RR359 Emma Glass

© Crown copyright and database rights
2025 Ordnance Survey AC0000808122

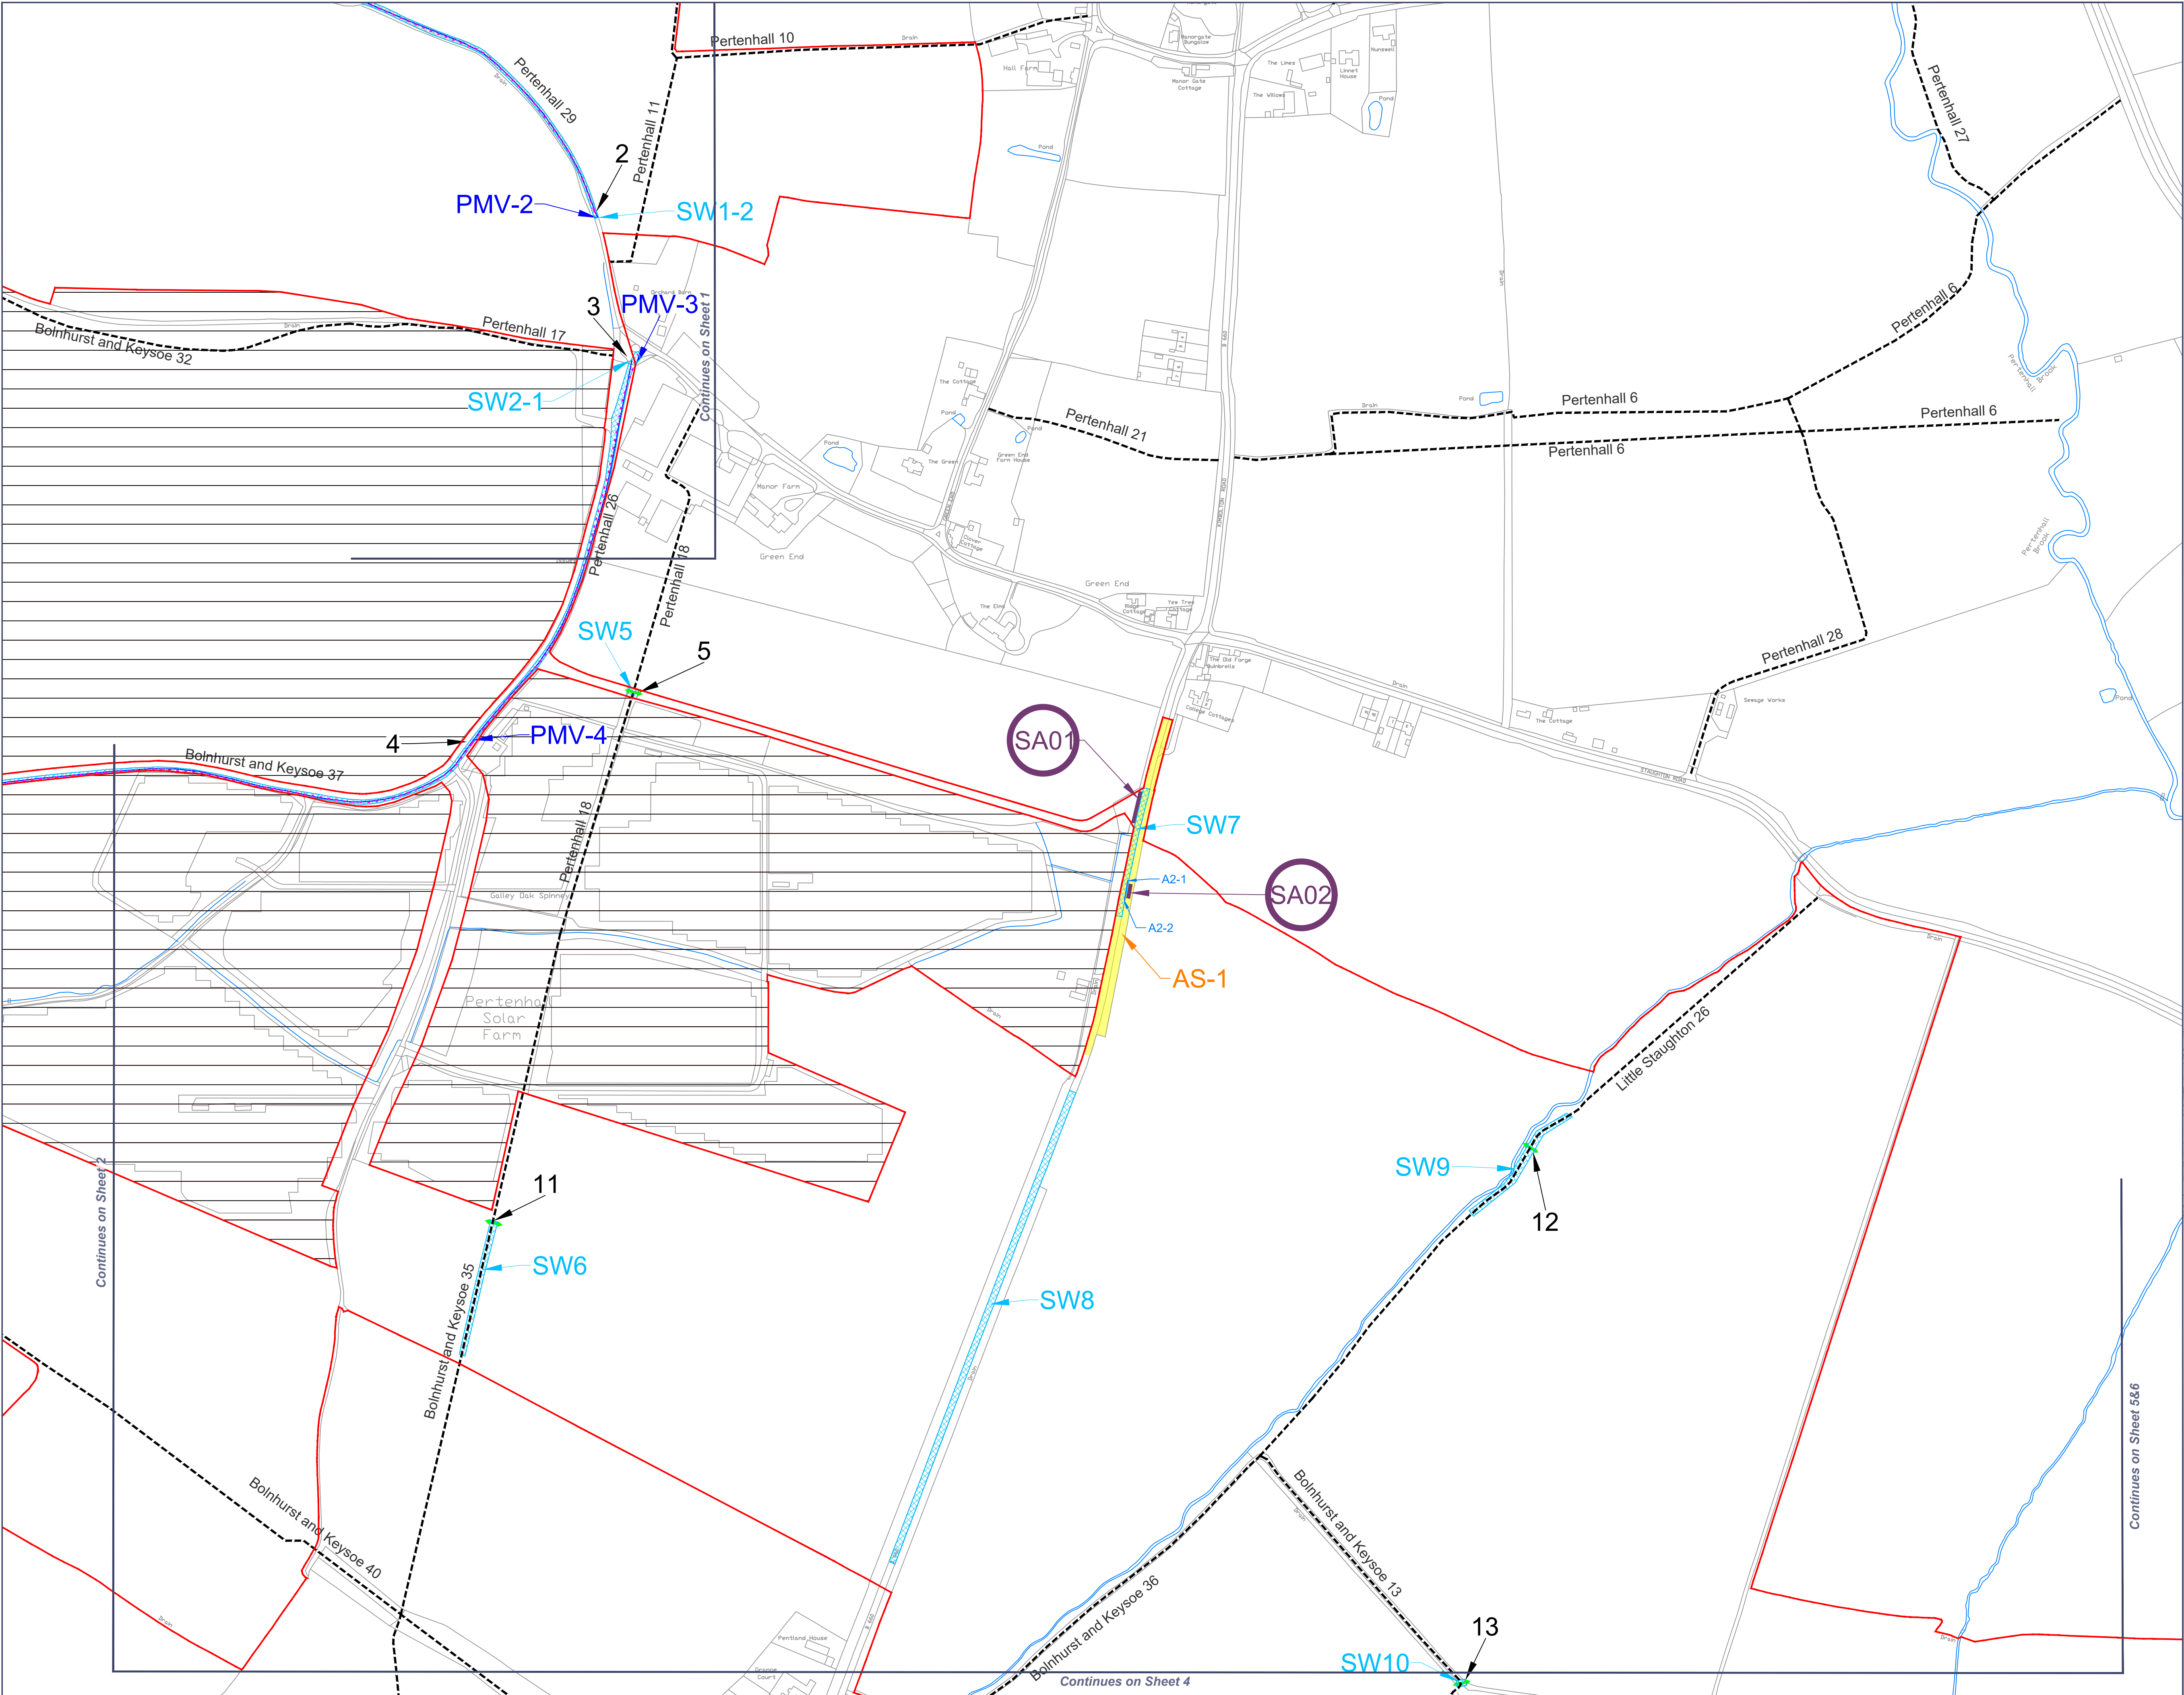
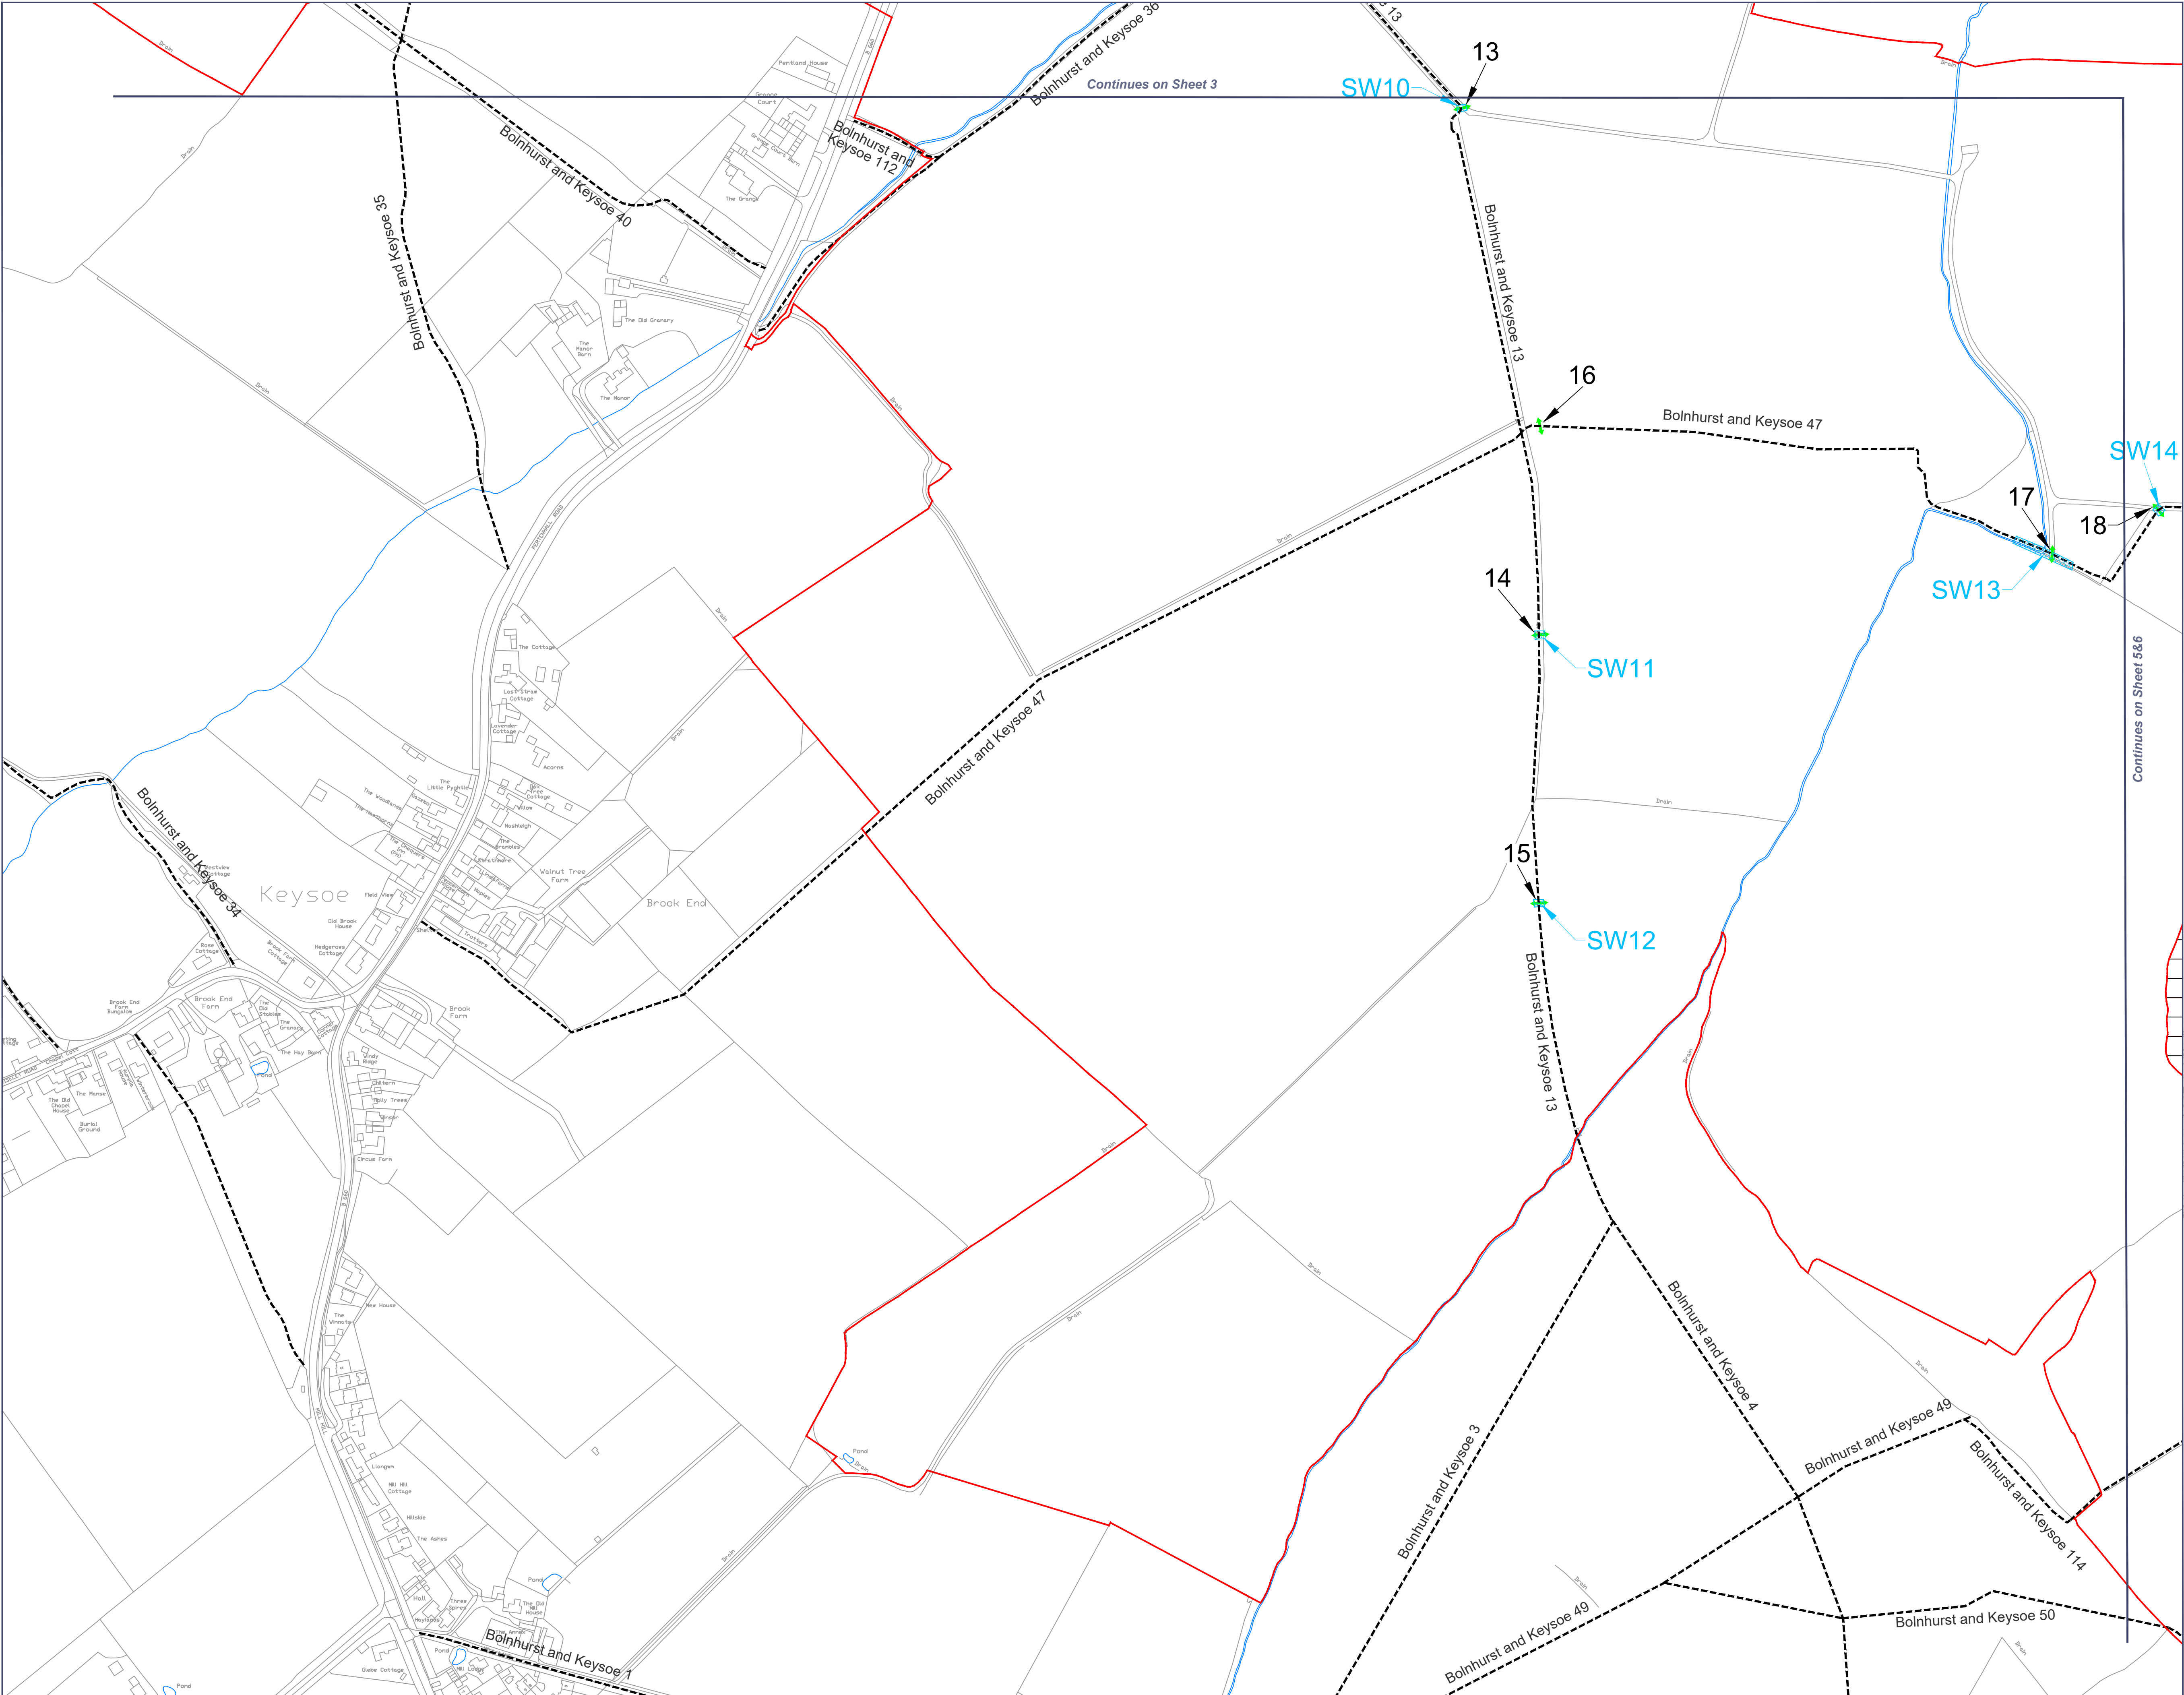
Finally, there is the issue of public rights of way. The suggestion that footpaths and bridleways will remain safely accessible during a 30-month construction period is unrealistic.

How will the safety of walkers, cyclists, and horse riders be guaranteed in practice?
